Our Ref: F2025/00890
(Contact Officer: Joseph Edmonds, ph: 9093 6955)

Reference number	SSD-81426710
Subject Land	138 Maroubra Road, Maroubra
Proposal:	Construction of a nine-storey mixed-use development comprising a residential flat building and ground floor retail premise, including: - 27 x 1-bed apartments, including 7 affordable dwellings - 14 x 2-bed apartments, including 6 affordable dwellings - 23 x 3-bed apartments - Communal open space at rooftop level and on level two Replacement of an existing single level of basement to provide basement car parking, plus additional parking provided above ground on the first storey. The application is seeking an infill affordable housing bonus under the SEPP Housing 2021, noting that 13 affordable housing units are proposed within the scheme.

I refer to your request for Council's review of the Mixed-use development with in-fill affordable housing at 138 Maroubra Road, Maroubra. The following comments are provided for your consideration.

DRAWN BY	SCALE	SHEET SIZE	PRINT DATE
Author	1:100	A1	18/09/2025
DESCRIPTION	SECTION A		
5:10:23 PM

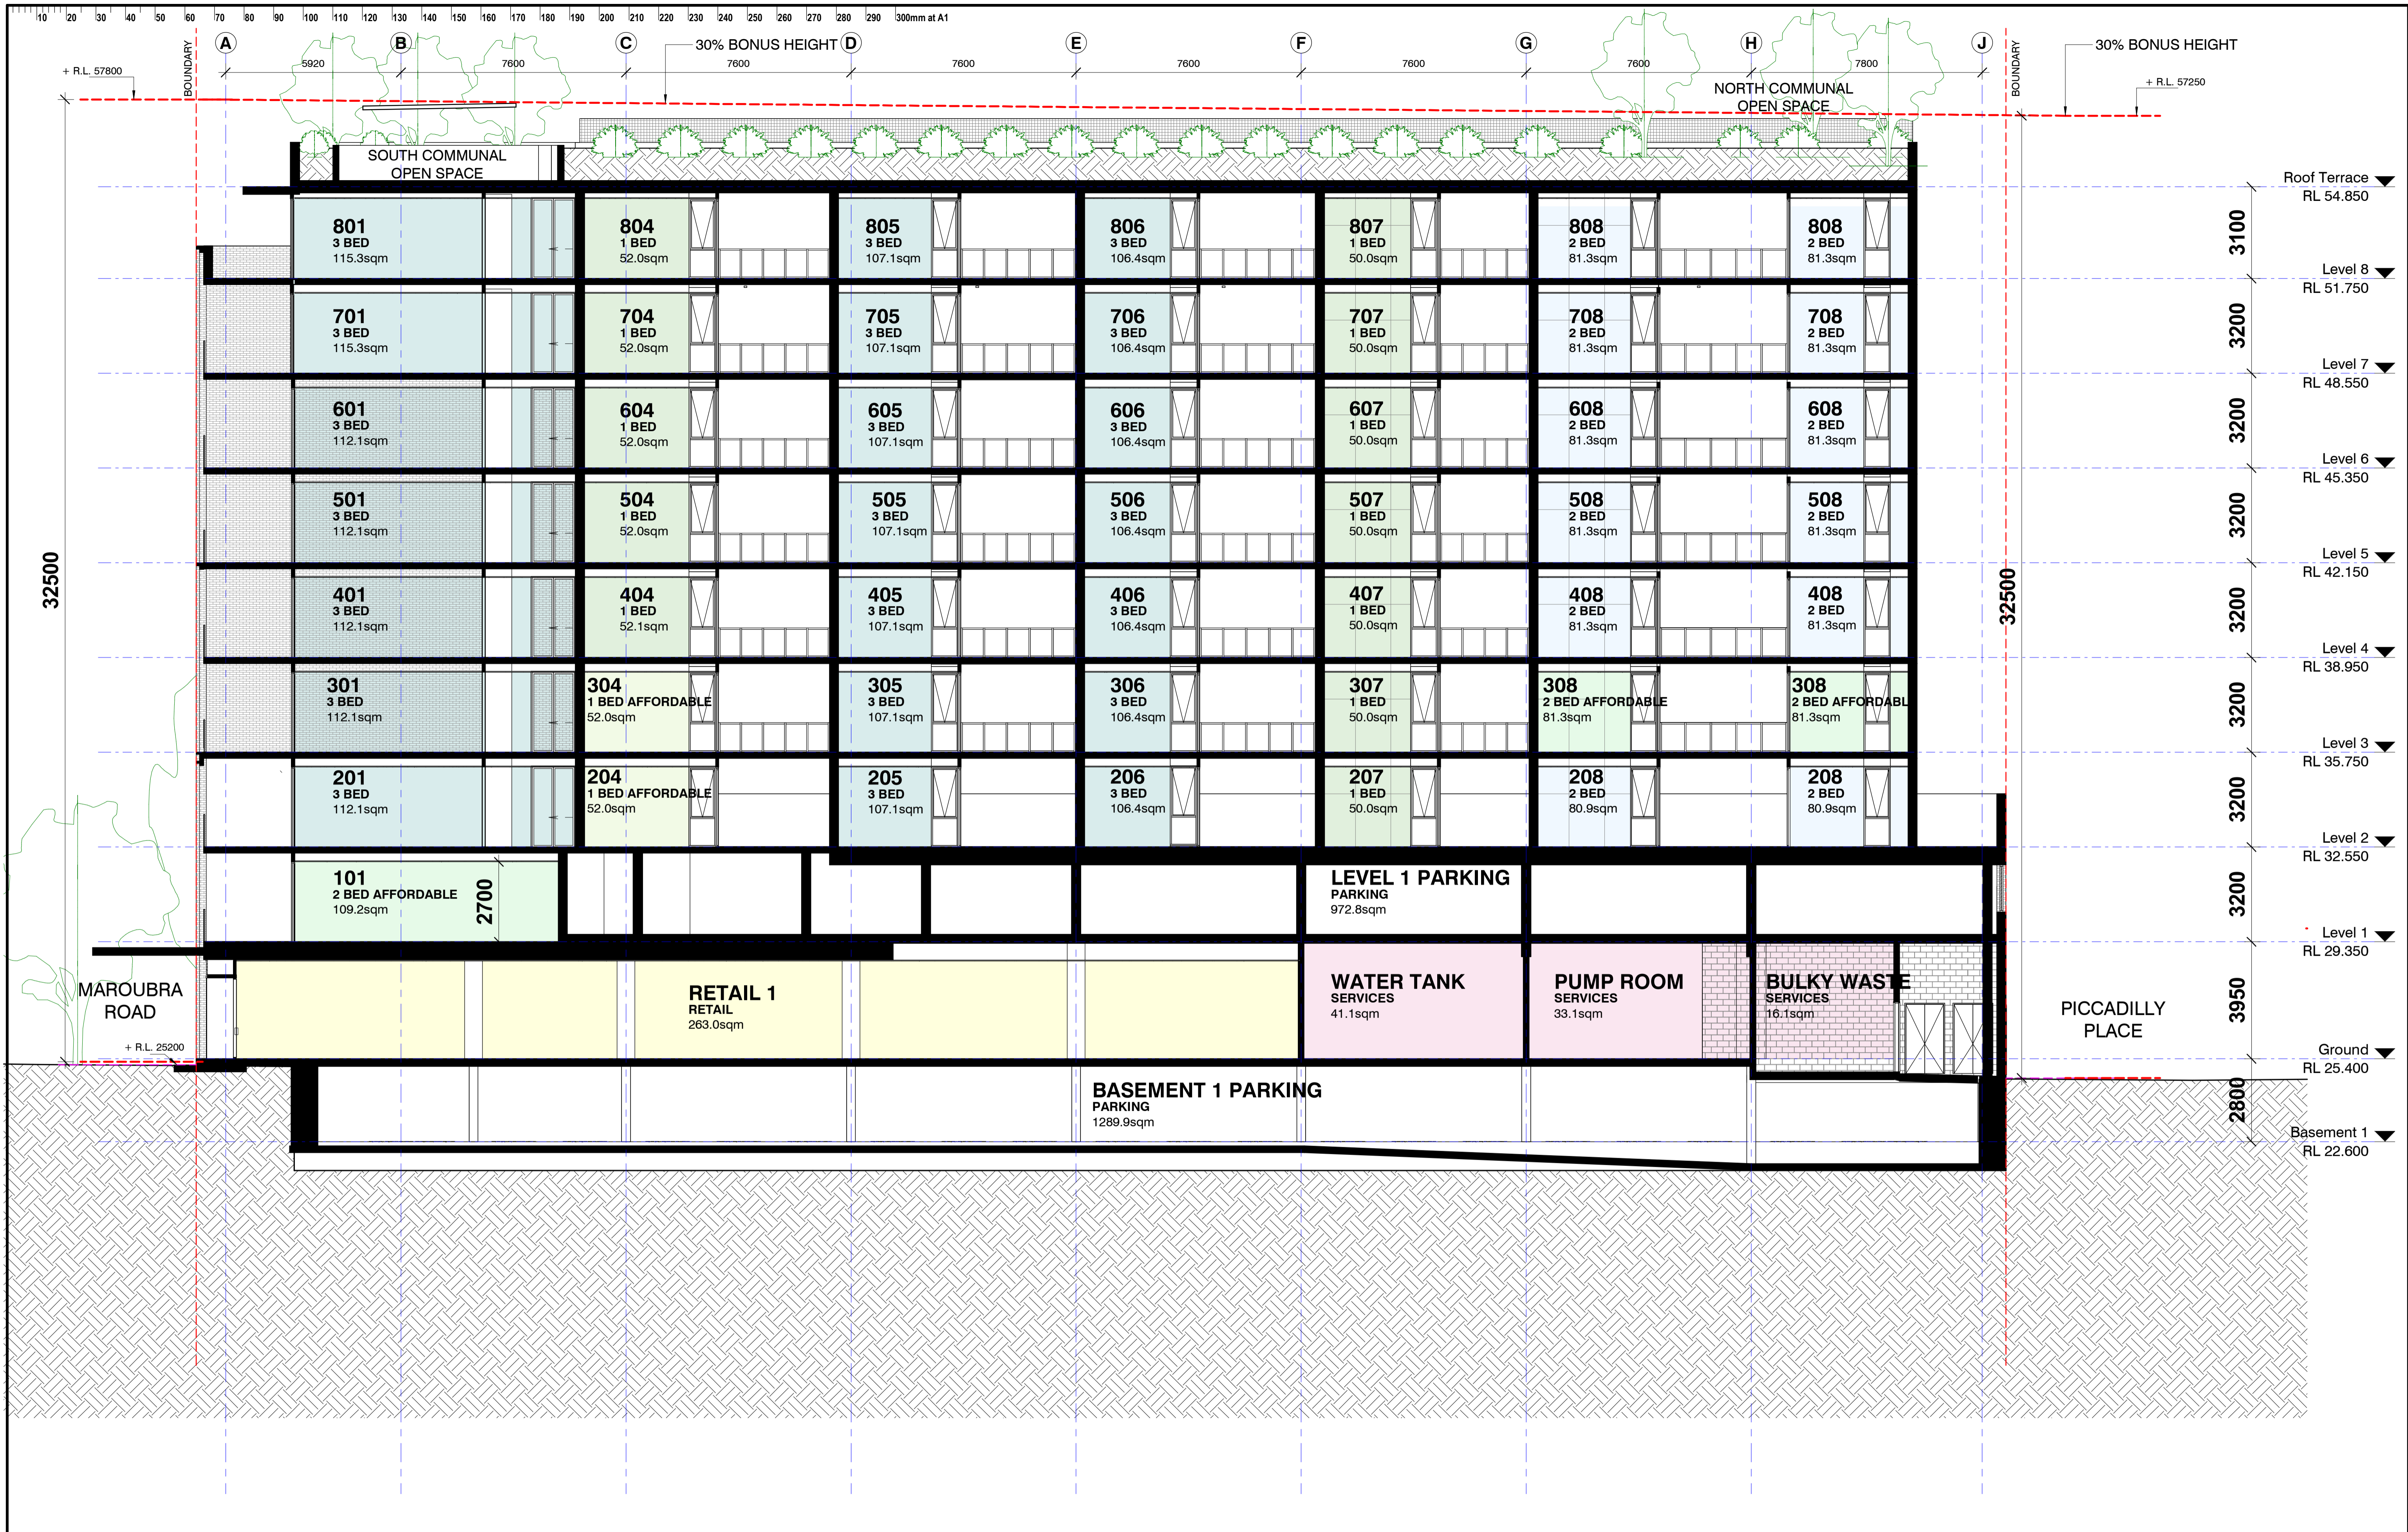
Councils' methodology for measuring building height is to take the existing ground level (being the underside of the existing basement level slab) RL 22.52 and calculate what the building height is based off the maximum height of the building in accordance with the most recent direction of the NSW LEC.

The maximum overall height of the development being the pergola structure is at RL 57.8, as shown below.

The maximum building height is 35.28m. Therefore, the development exceeds the AFH Bonus height of 32.5m by 8.55%.

No Clause 4.6 Variation Request has been provided for assessment and as such it is not considered that consent cannot be granted in the absence of a variation request.

DRAWN BY	SCALE	SHEET SIZE	PRINT DATE
Author	1:100	A1	18/09/2025
DESCRIPTION			REVISION
WEST ELEVATION			5:15:36 PM
PROJECT No	DRAWING No	REVISION	
21_435	DA2.203	N

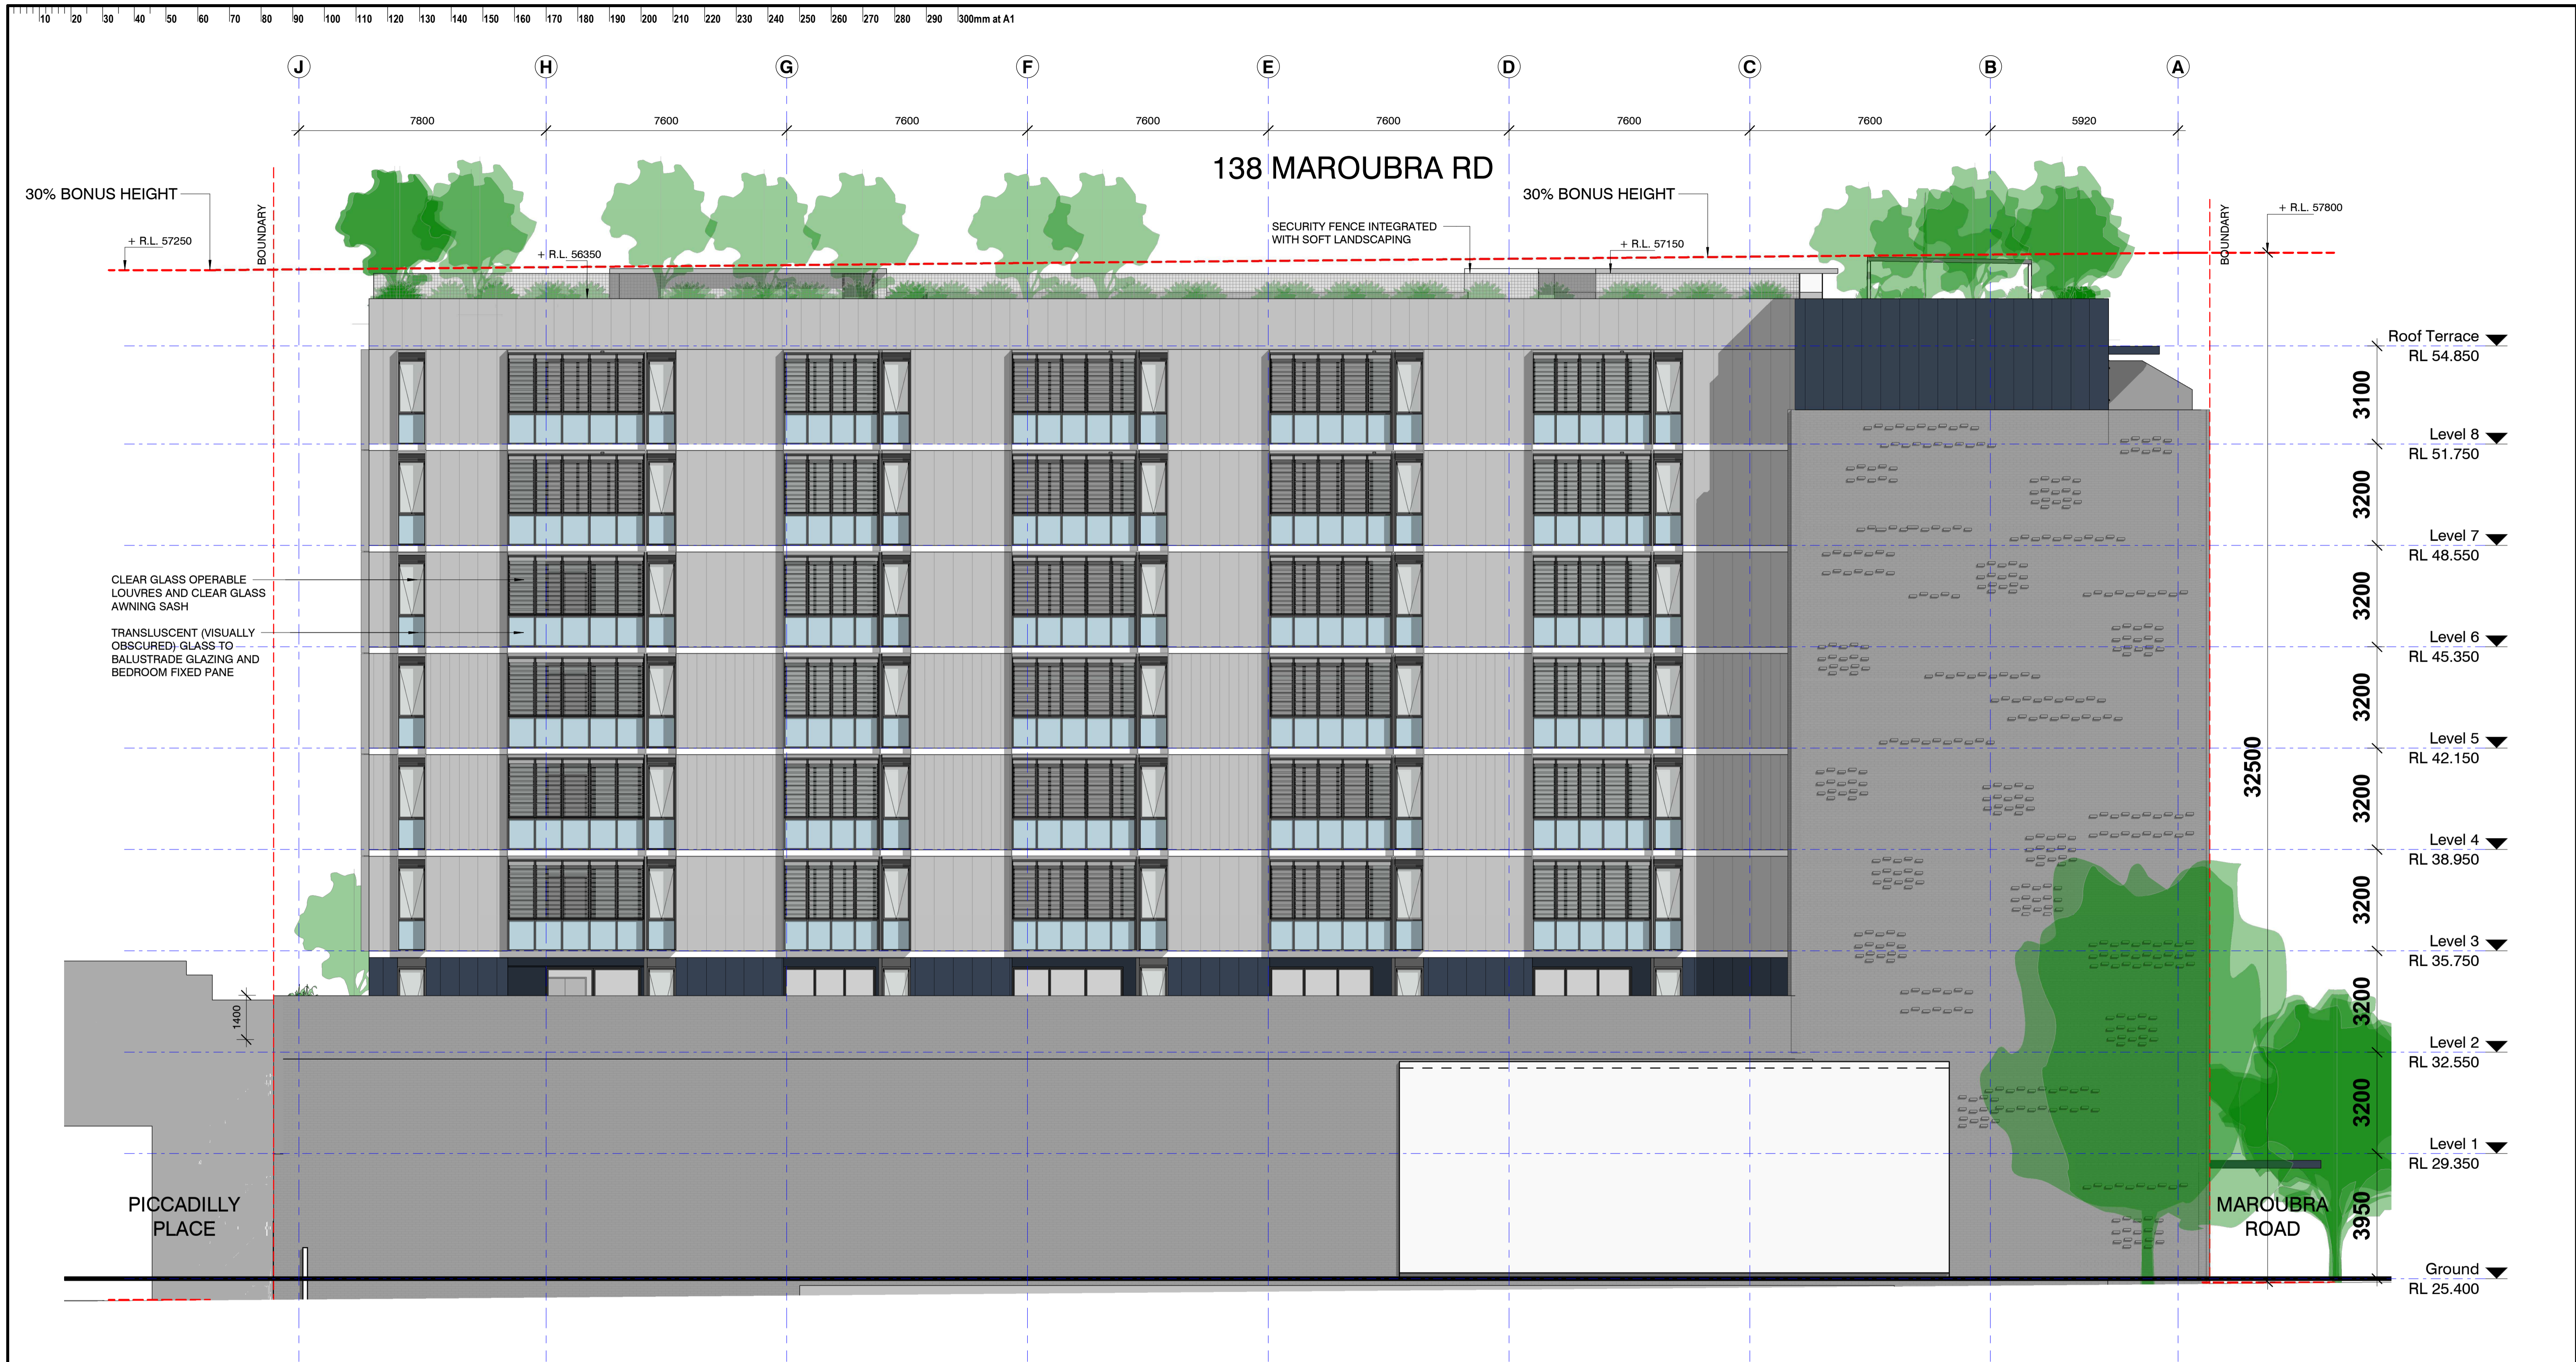
The side facing balconies to the west are not appropriate. These balconies are enclosed on three sides and as shown below proposed to be fitted with windows and louvres in a wintergarden arrangement. Council does not consider these afford sufficient amenity to future occupants in terms of private open space.

Additionally, the orientation of these rooms is not appropriate.

The proposal includes a wall of 45m in length along the western side of the development, with only inset balconies, which council considers will present as predominantly enclosed areas, as per the assessment above. This significantly exceeds the building depth controls and it will result in the presentation of unacceptable bulk and scale for 136 Maroubra Road.
